CITY OF ALBUQUERQUE

Re: Fairfield, 4875 Pan America Freeway
Request for Certificate of Occupancy
Transportation Development Final Inspection
Architect's Stamp dated 10-27-15 (F17D006B)
Certification dated 12-1-17

Based upon the information provided in your submittal received 12-1-17,
Transportation Development cannot approve the release of Certificate of Occupancy
for the above referenced project.

Site Development Plan For Building Permit
Proposed 89 Room Hotel
4875 Pan American West Freeway NE
Albuquerque, NM
A001

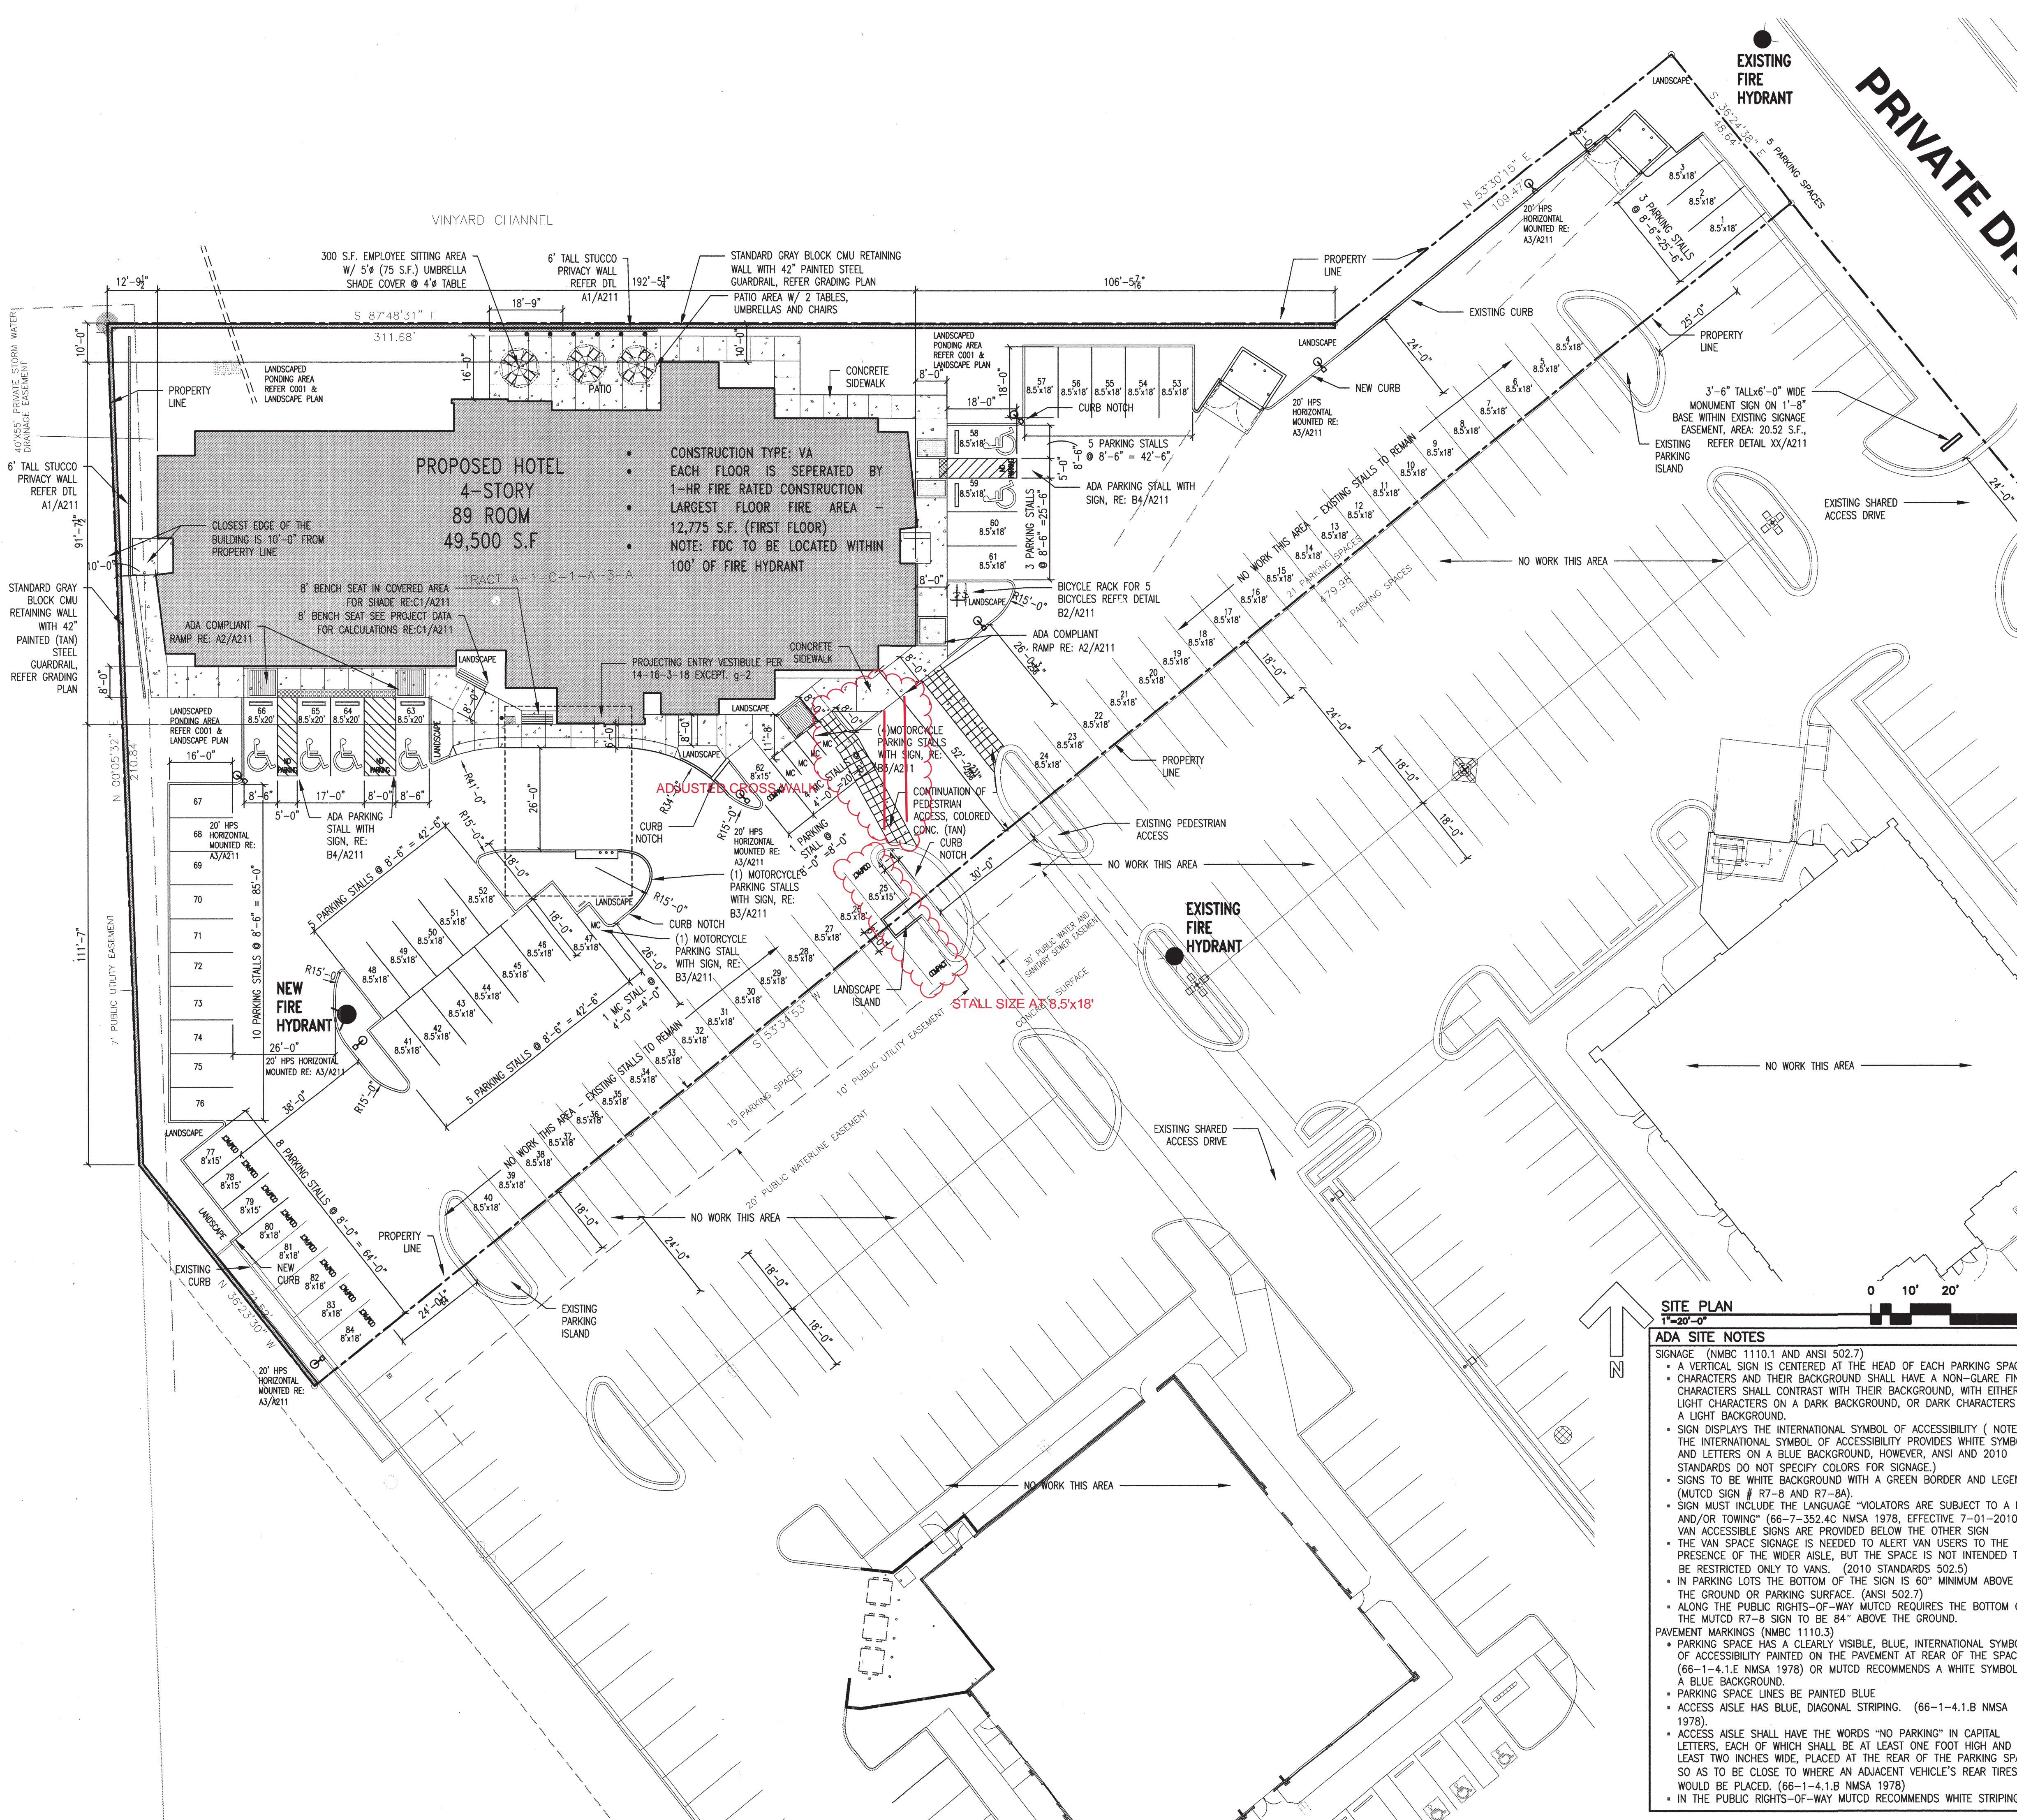
- Remove construction equipment and debris.
- Label the compact parking spaces by placing the words "COMPACT" on the
pavement of each space.
- The 6' pathway on the southeast side of the site has not been constructed per
the plan.
